**Consultation Response from KC,
Highways Development Management**

2024/90273 adj, 53, Garden Place, Dewsbury Moor, Dewsbury, WF13 4EP

Erection of two semi detached dwellings

Date Responded: 26-3-2025

DRAWING TITLE
Site Block Plan
REV 01

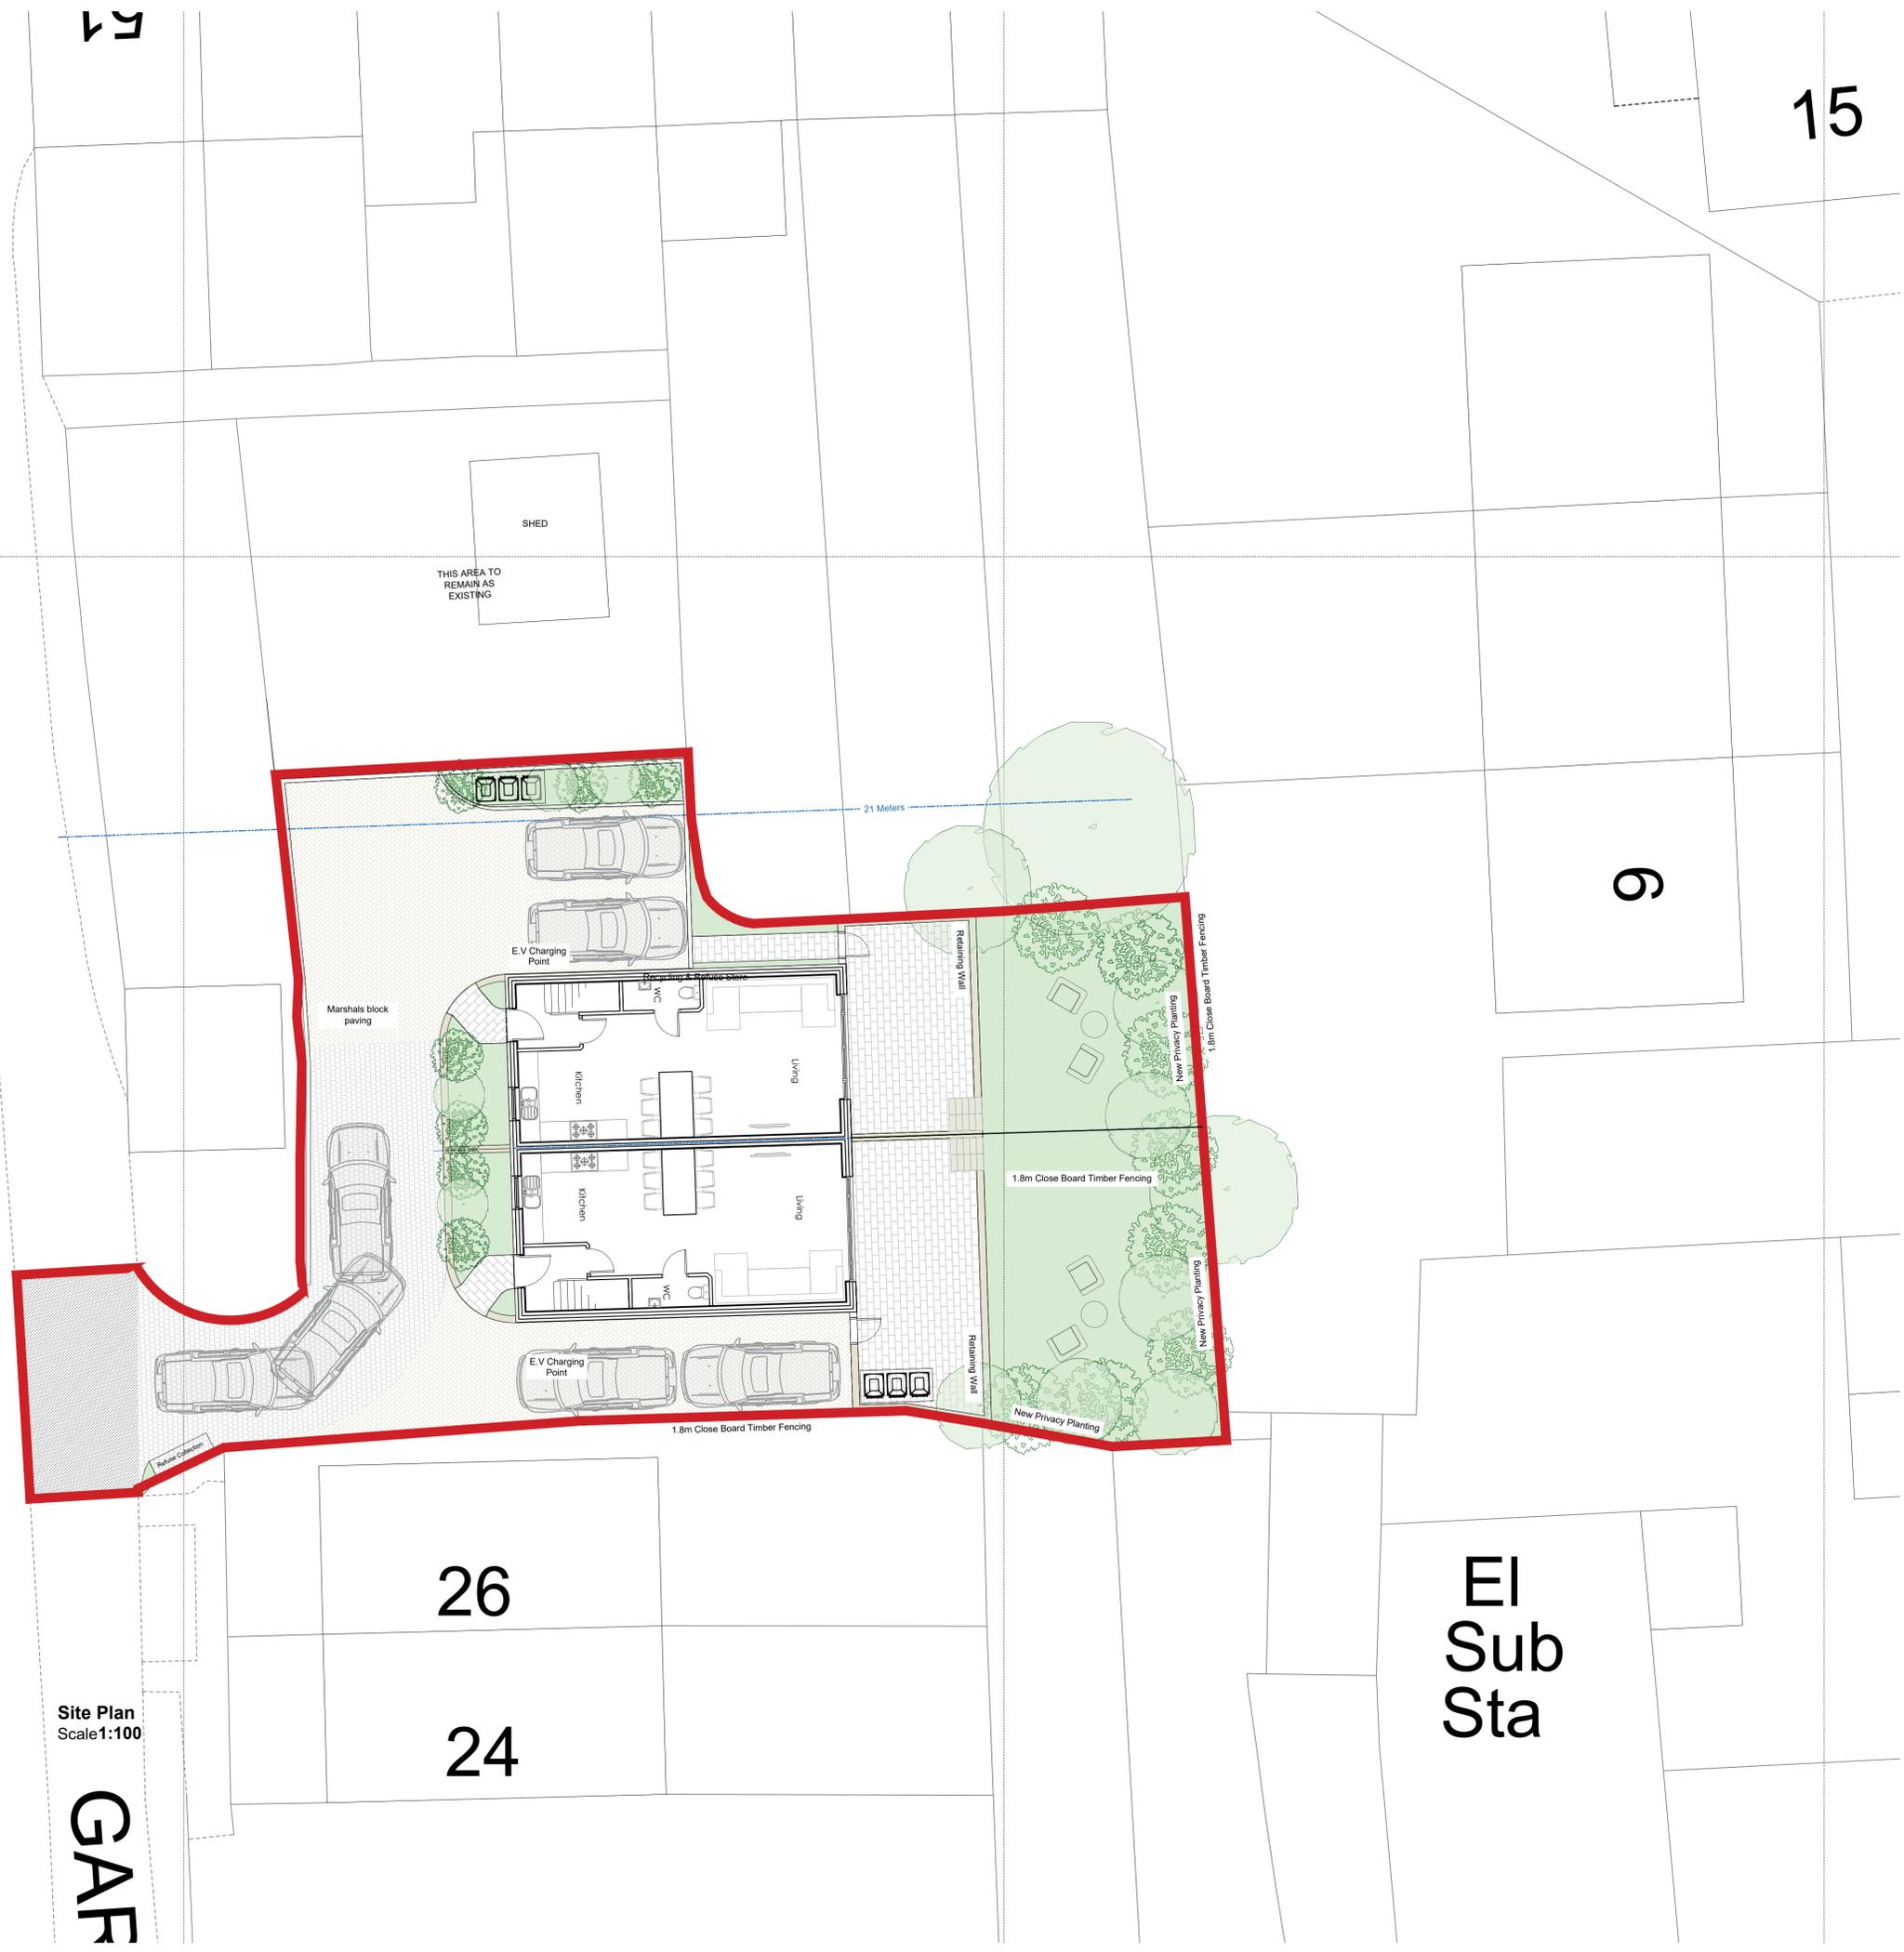
The widening to the access (Garden Place) is not shown and these proposals cannot therefore be considered acceptable

Plan number HA-23-08-03 Site Block Plan rev 2 now shows Garden Place shall be constructed to a width of 4.0m.

Whilst these proposals are now considered acceptable no details of how Garden Place is to be reconstructed to a 4.0m width are provided. Highway Development Management would therefore recommend that the condition is reworded to require construction details.

Suggested condition.

Prior to development commencing, a detailed scheme for the widening of Garden Place between the proposed site access and Church Lane shall be submitted to and approved in writing by the LPA. The scheme shall include construction specifications, white lining, and surface finishes. Unless otherwise agreed in writing by the LPA, all the agreed works shall be implemented before any part of the development is first brought into use. and shall thereafter be retained and maintained for the lifetime of the development. Reason: In the interests of Highway Safety
